Development Control
Ribbles Valley Borough Council

App no: 3/2022/0537

Address: Land Adjacent to Ferns Northcote Road Langho BB6 8BG

Proposal: Proposed residential development of 8 detached dwelling houses

Drawing No.  
2203-PL-05

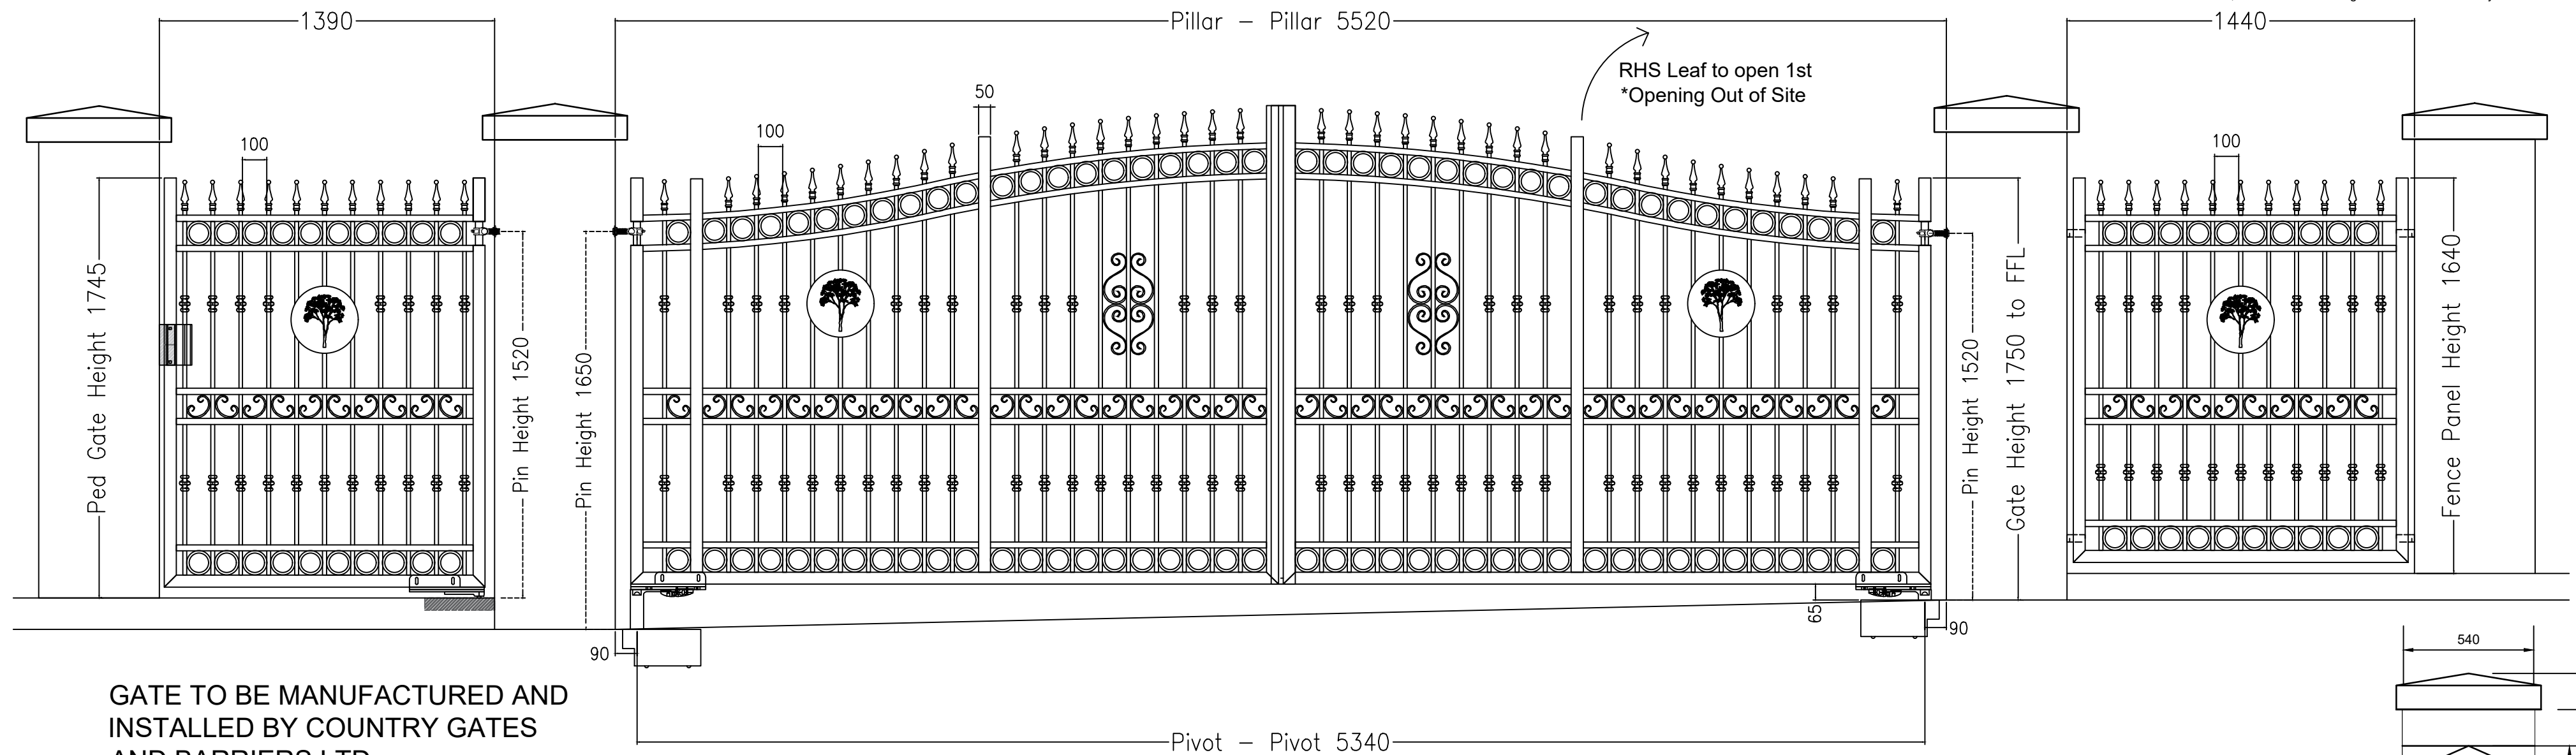
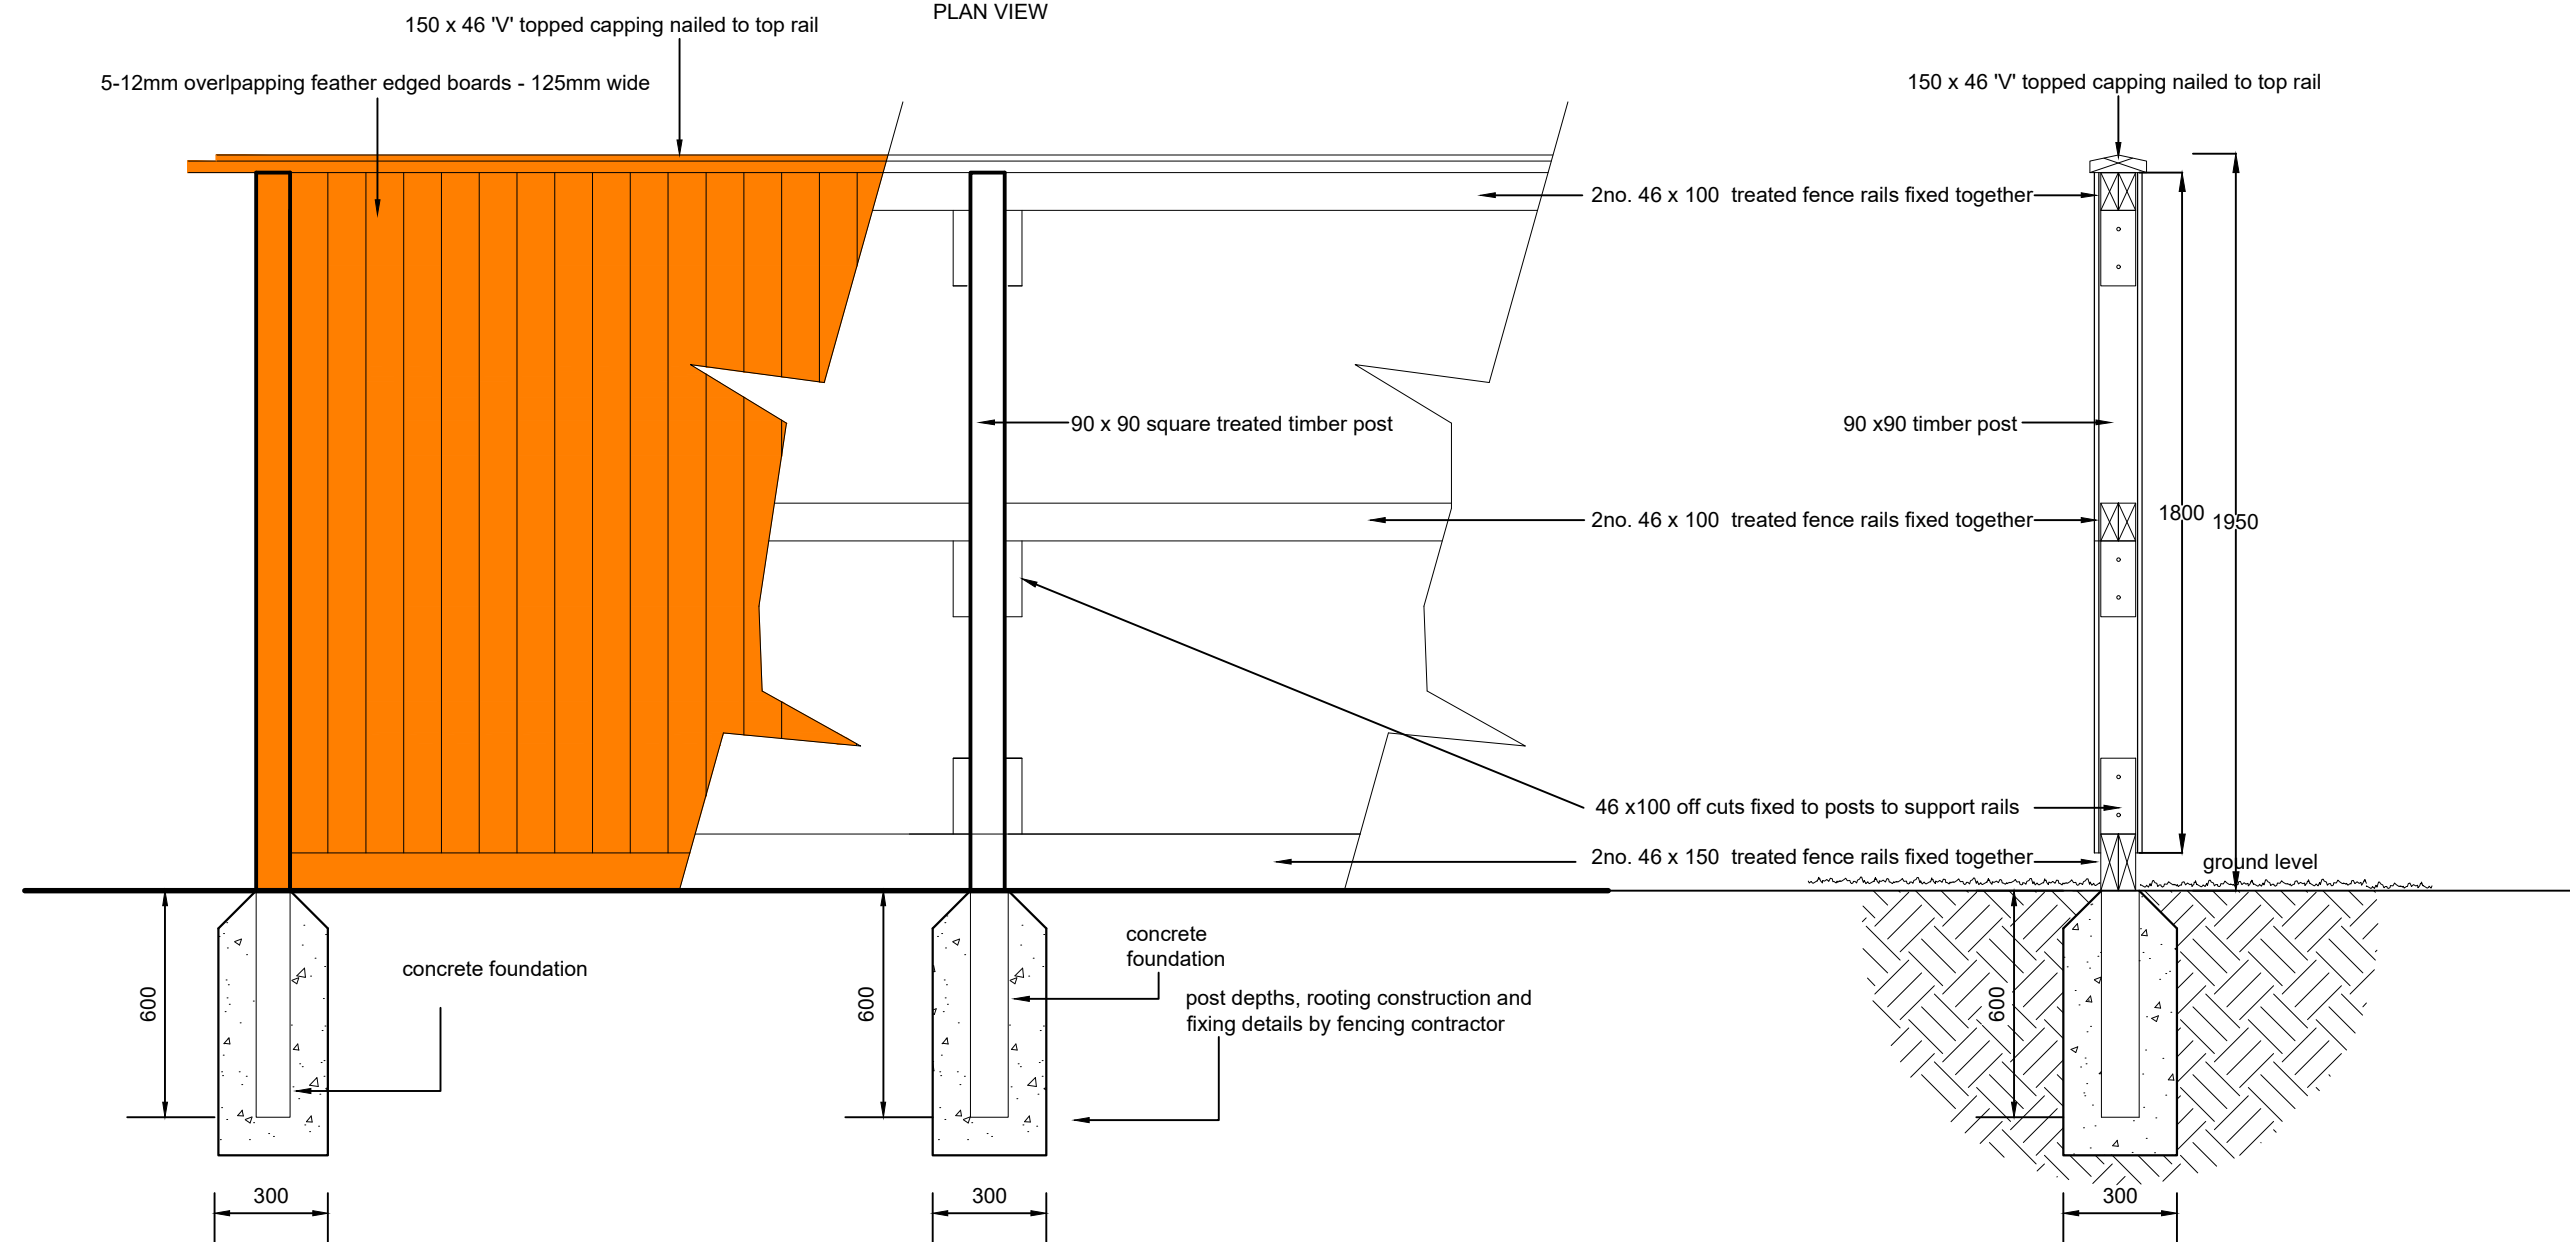
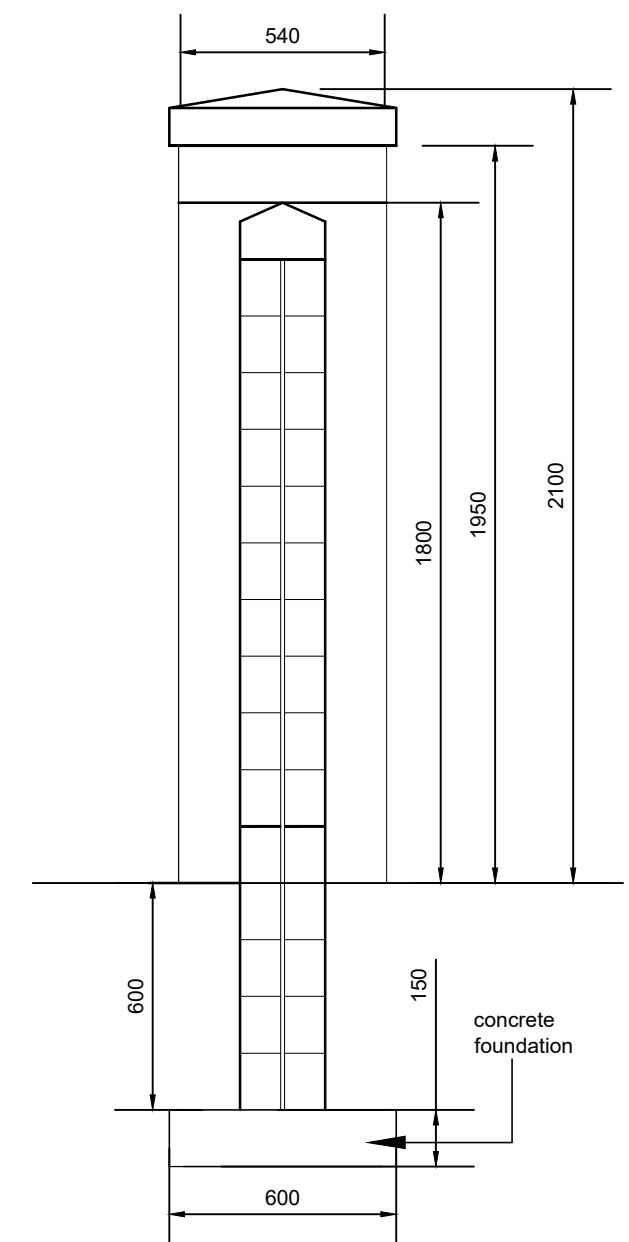
The estate road remains gated with gates being set back 9.525m from the edge of carriageway. This will allow long vehicles to clear the carriageway whilst the gates are operated. The waste receptacles may need to be moved by the residents and

left adjacent to Northcote Road on collection days alternatively the gates could be left open of collection days for the refuse vehicle to enter. Suitable methods to collect the waste should be clarified by the Ribble Valley refuse team.

10. The gates shall be installed in accordance with the approved plans, they shall open away from the highway or be sliding and shall not be moved closer to the highway. Reason: To ensure long vehicles can clear the highway whilst the gates are operated.
